**CITY OF ALBUQUERQUE
PLANNING DEPARTMENT
March 27, 2013
DRB Comments**

PROJECT # 1009636

APPLICATION # 13-70485

RE: Tract 492, Town of Atrisco Grant, Unit 1

SKETCH PLAT OF
TRACT 492
UNIT 7
 TOWN OF ATRISCO GRANT
 PROJECTED SECTIONS 33, T.10N., R.2E., N.M.P.M.
 CITY OF ALBUQUERQUE, BERNALILLO COUNTY, NEW MEXICO
 MARCH 2013

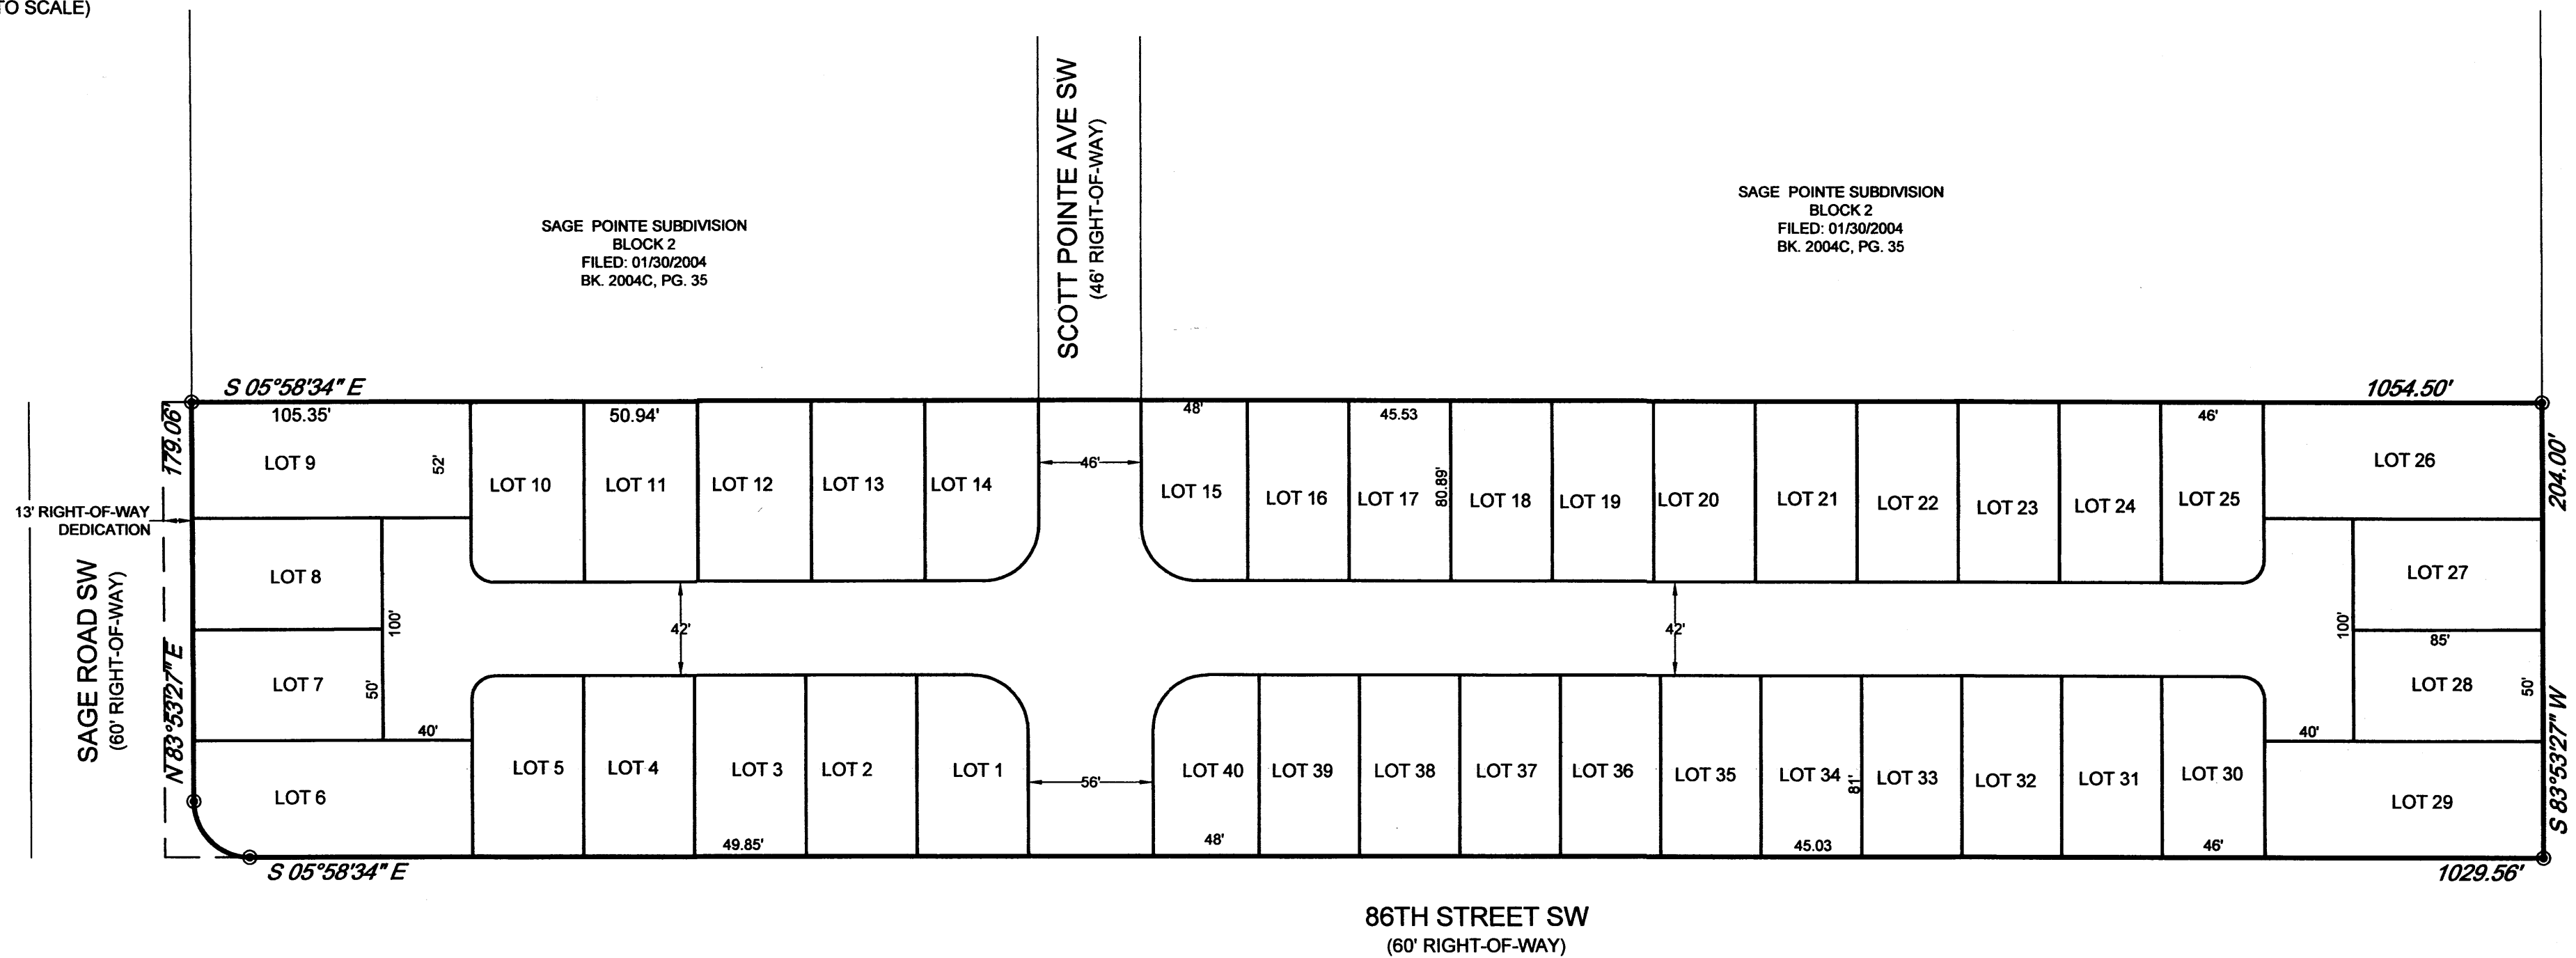
The site is zoned R-D/ 14 dwellings per net acre within the Tower/ Unser Sector Development plan. Compliance with the Open Space requirements of the R-D Zone must be demonstrated at the time of Preliminary Plat application, as well as Compliance with the Subdivision and Public Right of Way Regulations of the sector plan; it appears an additional access to Sage Rd SW will be needed.
